Your Ref: OWPC14378
Our Ref: P/46/17/HH 12-05-2017
Please ask for:
Richard Temple

Retrospective application for a flat roof single storey extension
94 Harbour View Road Pagham

ELEVATIONS. [As Proposed]	
Scale	1:100
Date	FEB.15
Drawn By	C.R.B.
Checked	
Drawing Number	1194-5
ABC/B

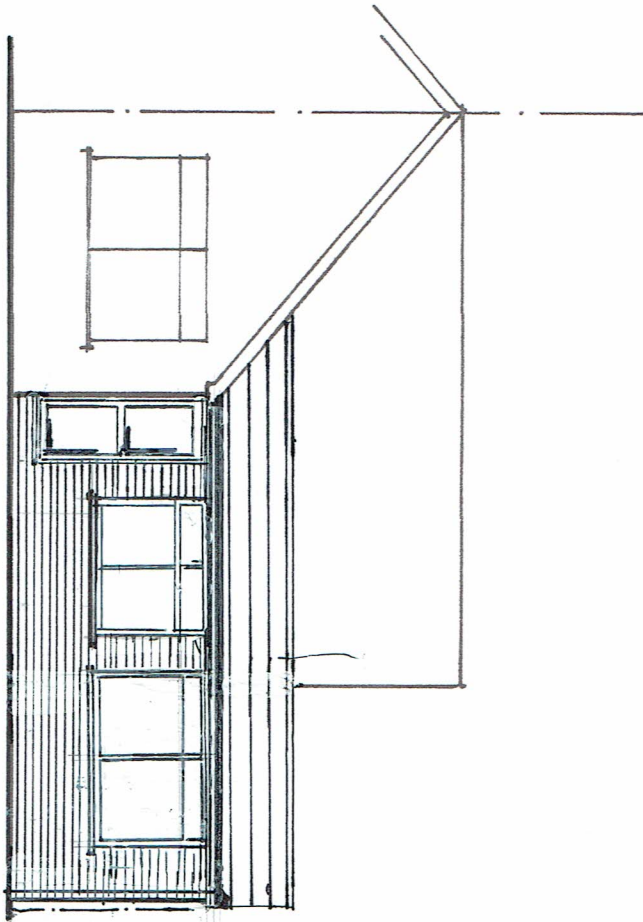
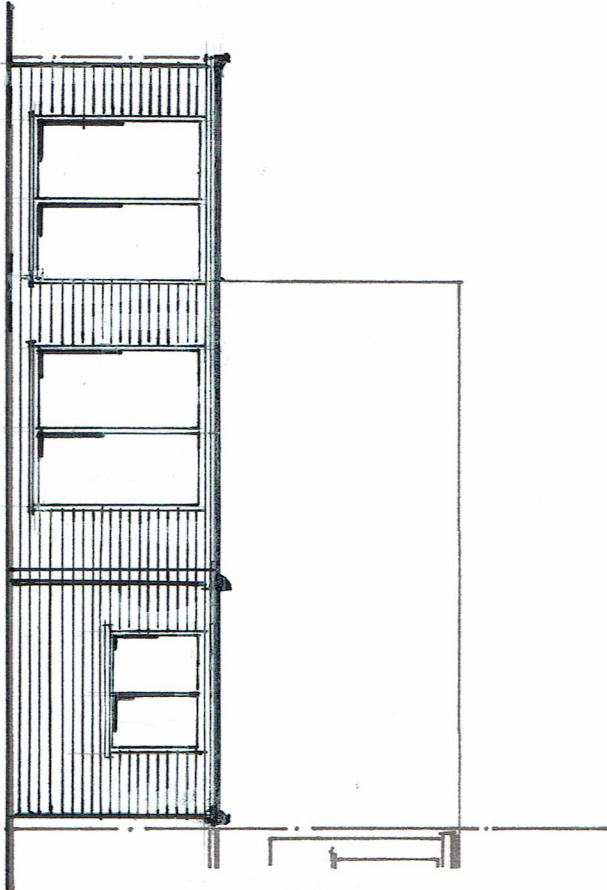
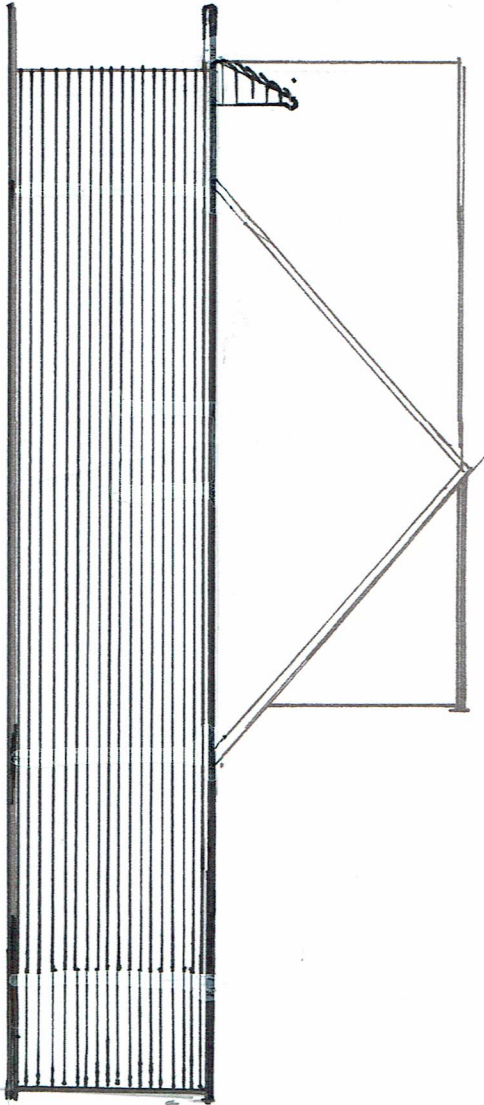
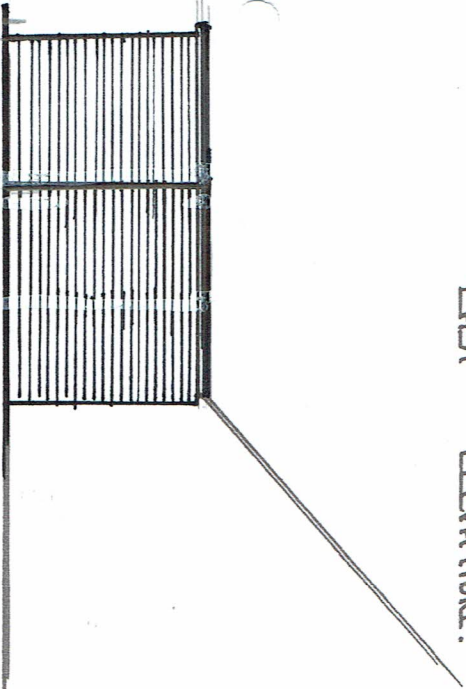
I have looked at this revised application and, as explained in my conversation with Chris Best cannot understand how a retrospective application can be submitted with the original plans. What has been built is almost twice the depth indicated on this plan and the roof line is above the level of the existing building. I understood that the retrospective application was intended to regularise this and seek consent for the 'new' building. Having lived with this for 2 years I am anxious to see it finished even if I am angry that the original consent has been frankly ignored. I do feel however that the correct permissions should be place to protect our position as we are attached to no 94. To be clear my concern is that it may cause issues with insurance cover or resale of our property if the extension is not correctly authorised.
